**PROPOSED RESIDENTIAL CONVERSION OF LISTED BARNs AT BEAUMONT HALL**  
**Application Ref. 19/01346/FUL & 19/1347/LBC**

**STATEMENT ON AMENDED DESIGN**

Including additional information on proposed insulation of historic building fabric.

KENNELS

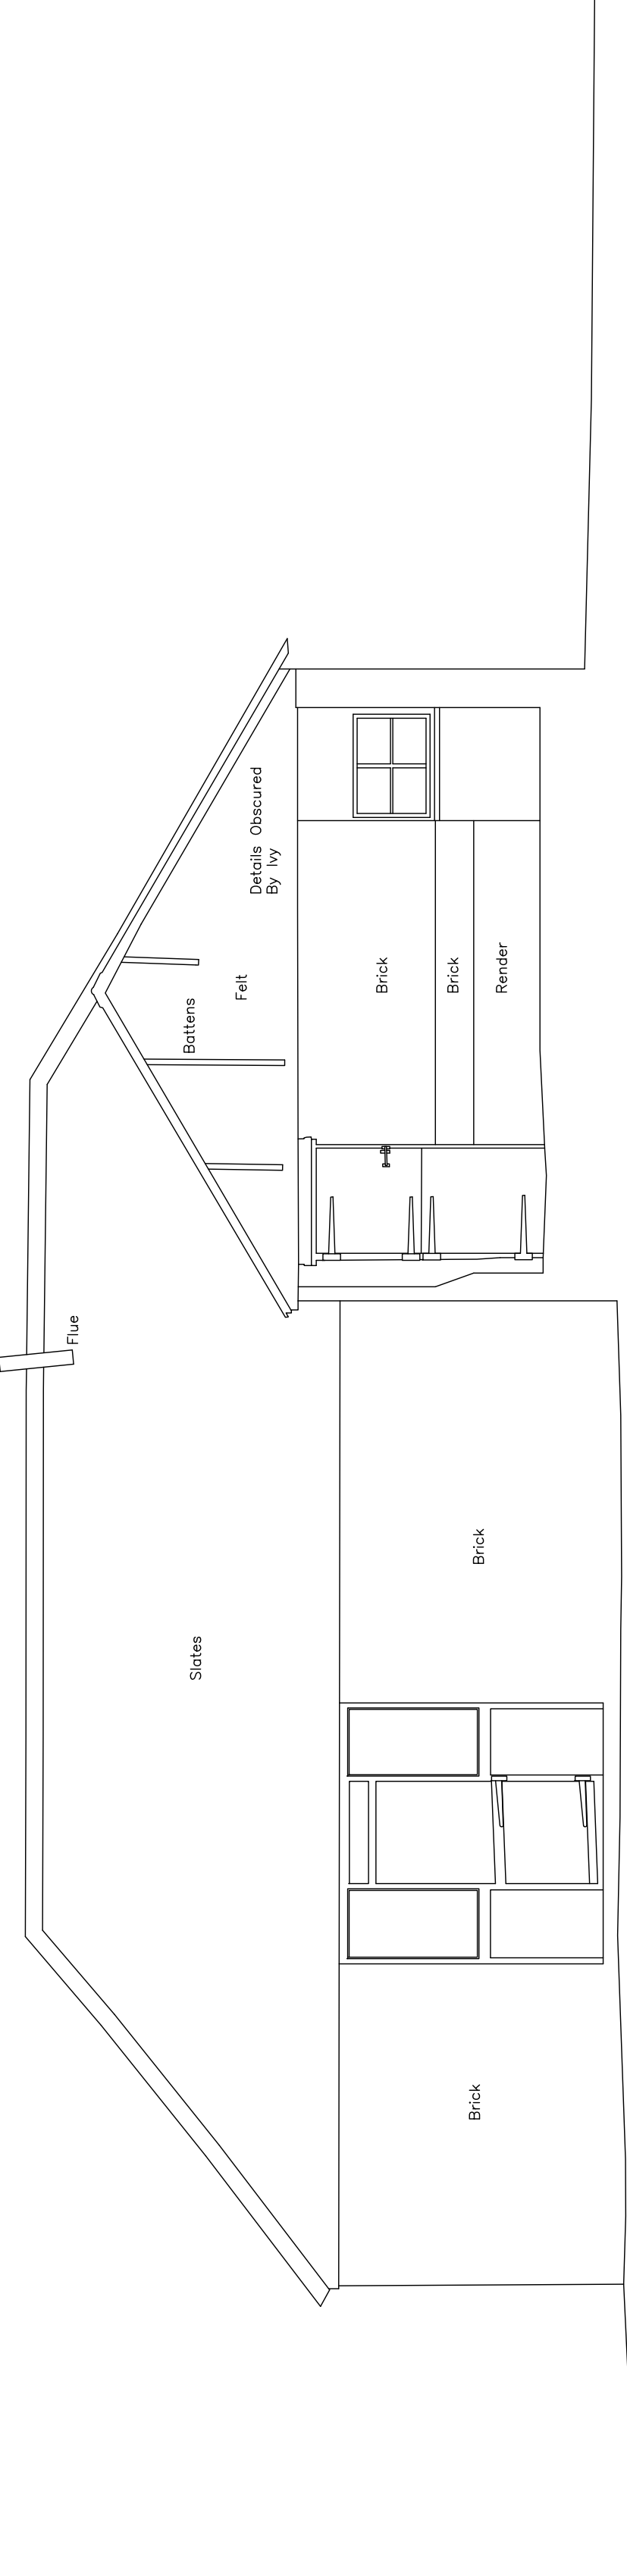
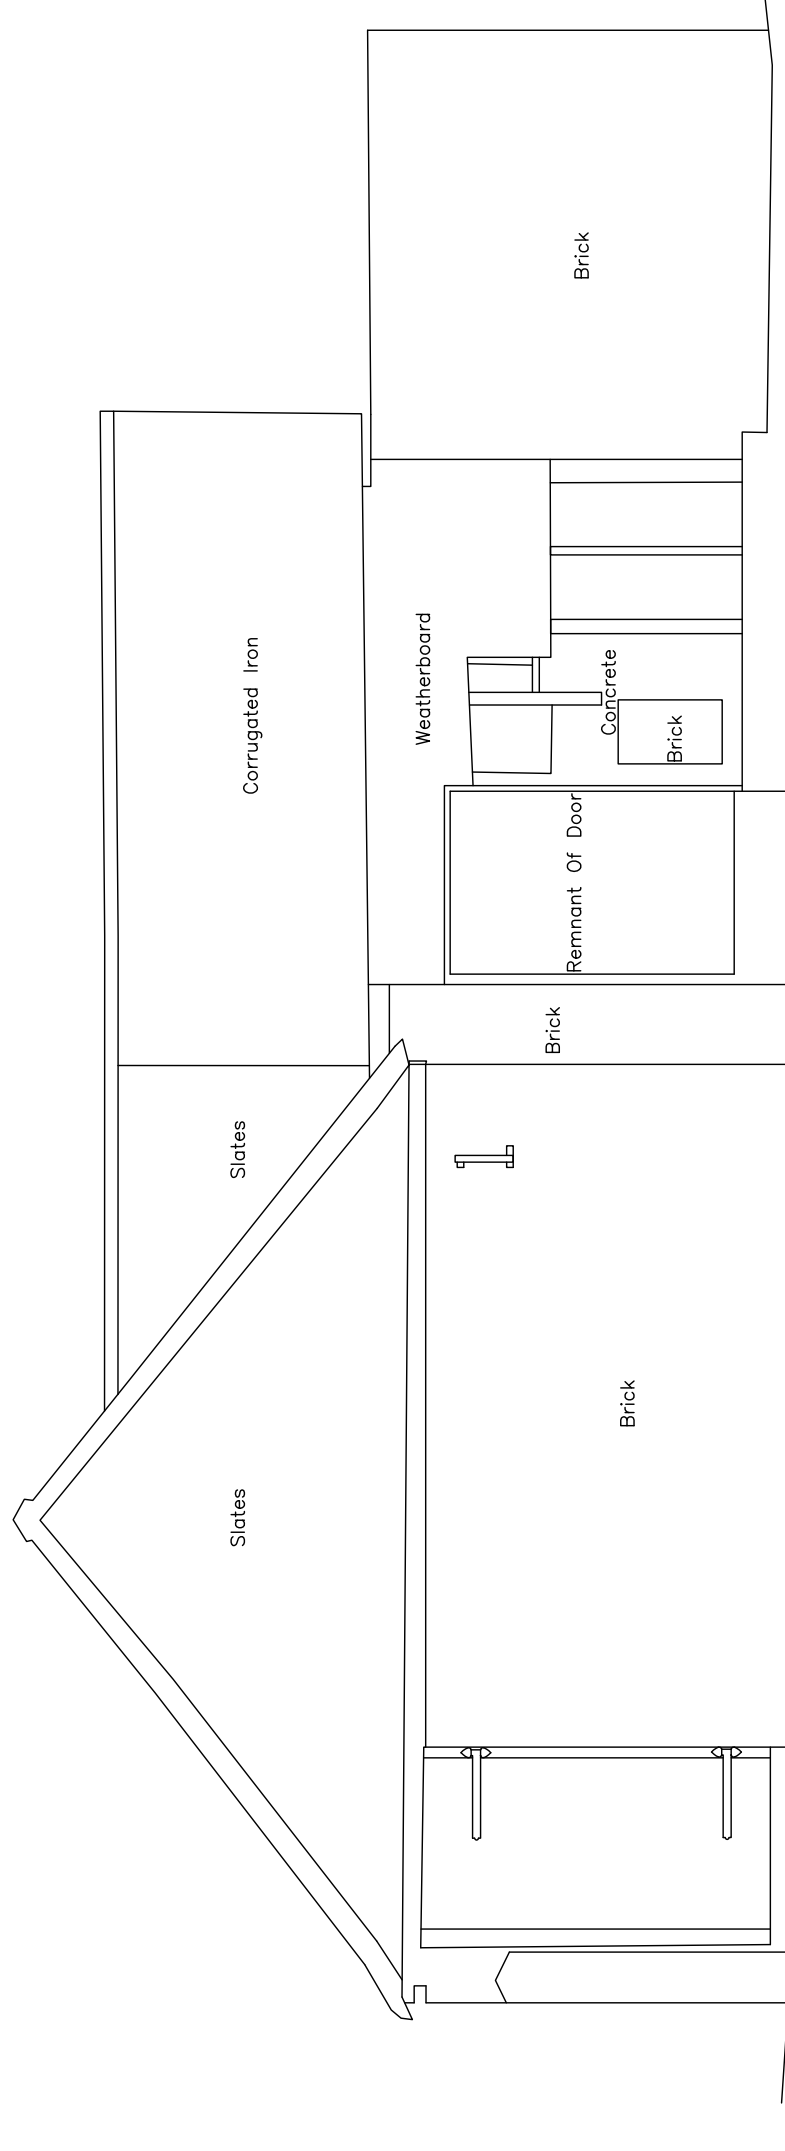
This late C19 building stands on the east side of the yard. Its original purpose is not known, but in recent years it was converted to house the dogs bred by the previous owner of Beaumont Hall. The kennels will be retained for parking and ancillary uses such as storage e.g. of bicycles, and bins.
